3rd March 2021

Application No: AB/1/21/L
Site Address: Walker House 14 Tarrant Street Arundel BN18 9DG
Description of works: Listed building consent for the renewal of existing slate roof, replacement of 2 No. window frames on front elevation & painting west elevation & rear garden north & east elevations.

OWPC34125

West roof slope—slipped slates lying in gutter ...

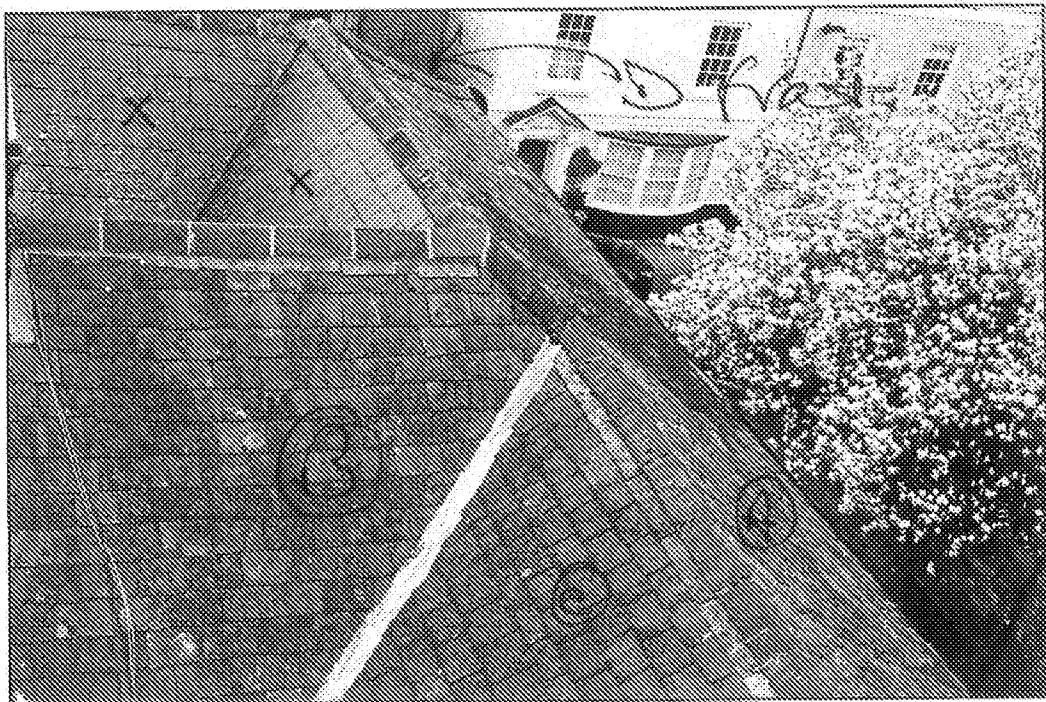
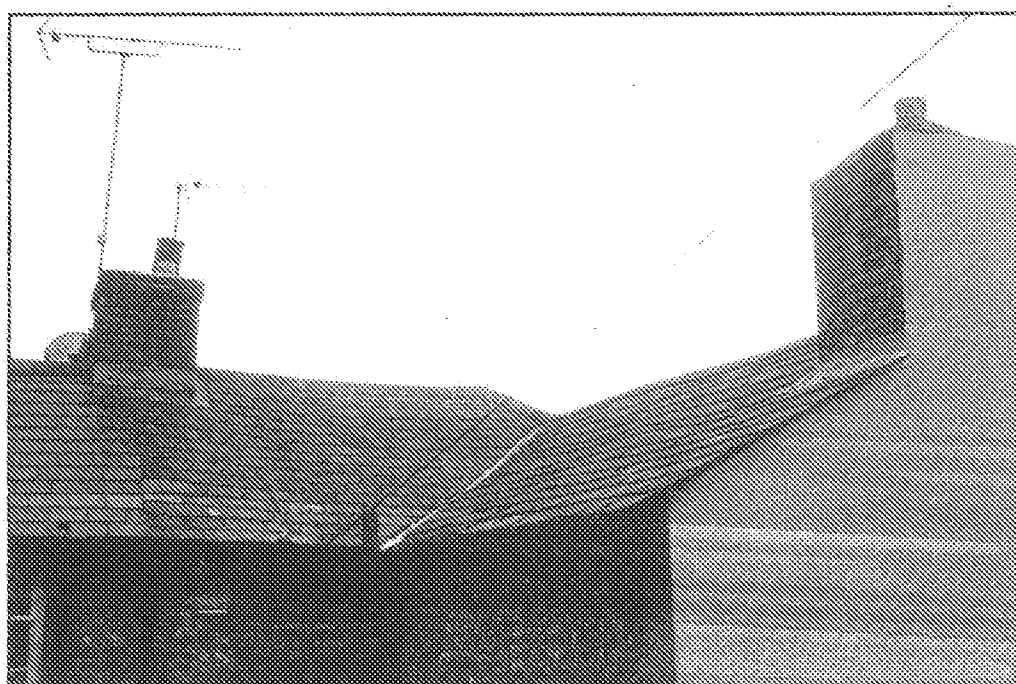
A sample of any replacement slate, and of bricks to be used in repair should be submitted to the Council for agreement. The Surveyor's report submitted with the Heritage Statement seems to indicate that replacement slates are required only for some of the internal roof slopes whereas the description implies total replacement. Perhaps this should be clarified since the replacement of any areas of sound slates on the roofs is clearly unnecessary.
